Application for removal or variation of a condition following grant of planning permission.
Town and Country Planning Act 1990.
Planning (Listed Buildings and Conservation Areas) Act 1990

Erection of 2 dwellings (plots 78 & 79), reconfiguration of plots 75, 76, 77, reconfiguration of highway turning head and design amendment to plot 71.

Replace the drawing listed as PD601(P1) with drawing PD601(P2).

3 BEDROOM DETACHED HOUSE (Plot 79)

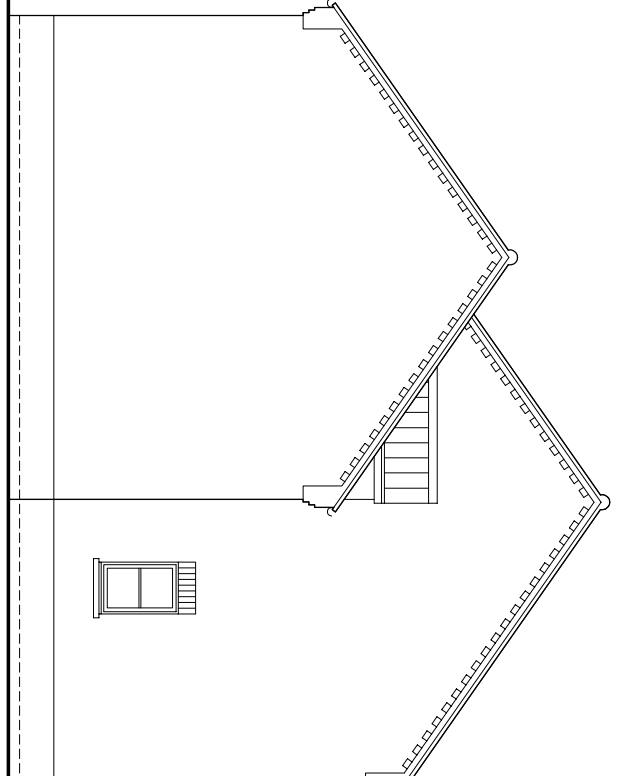
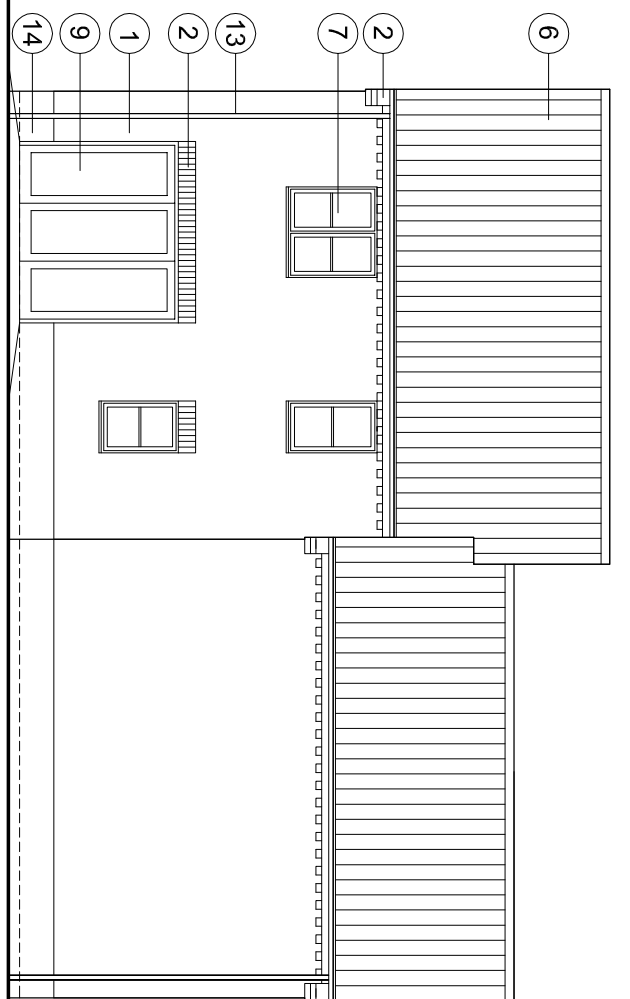
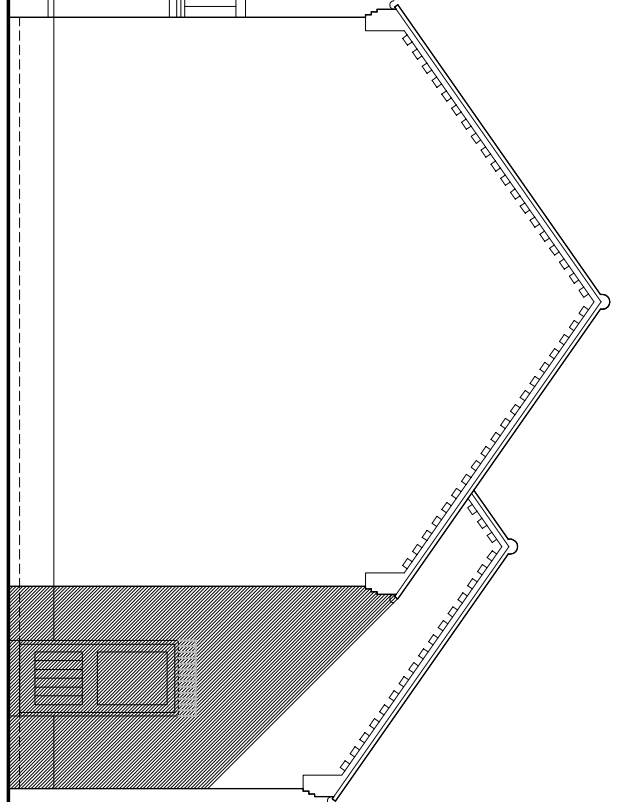
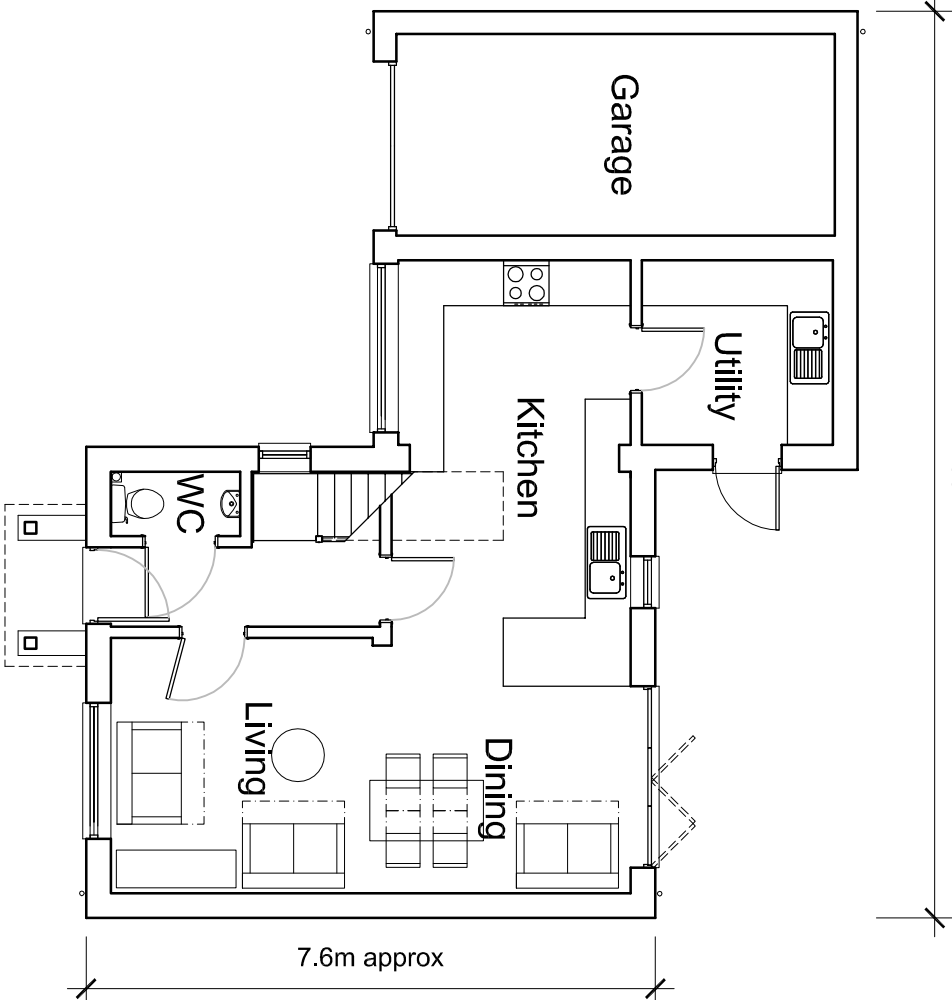
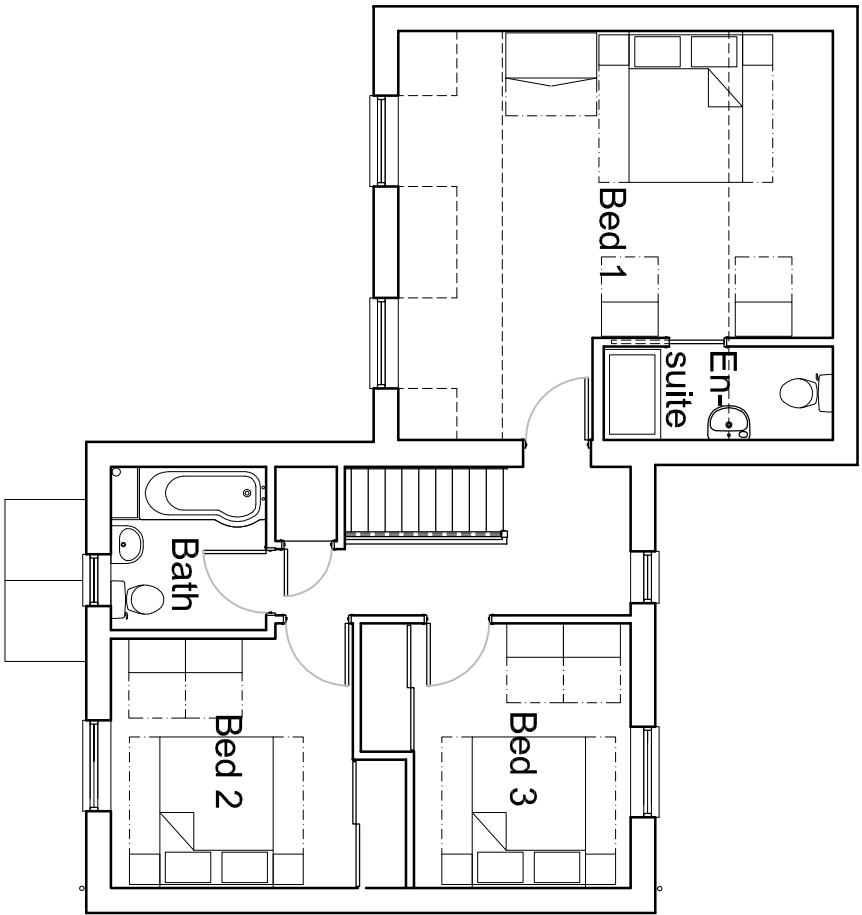
Plot 79 - Half of the garage replaced with kitchen & utility. Garage door replaced with window. Rear door changed from solid to semi-glazed.
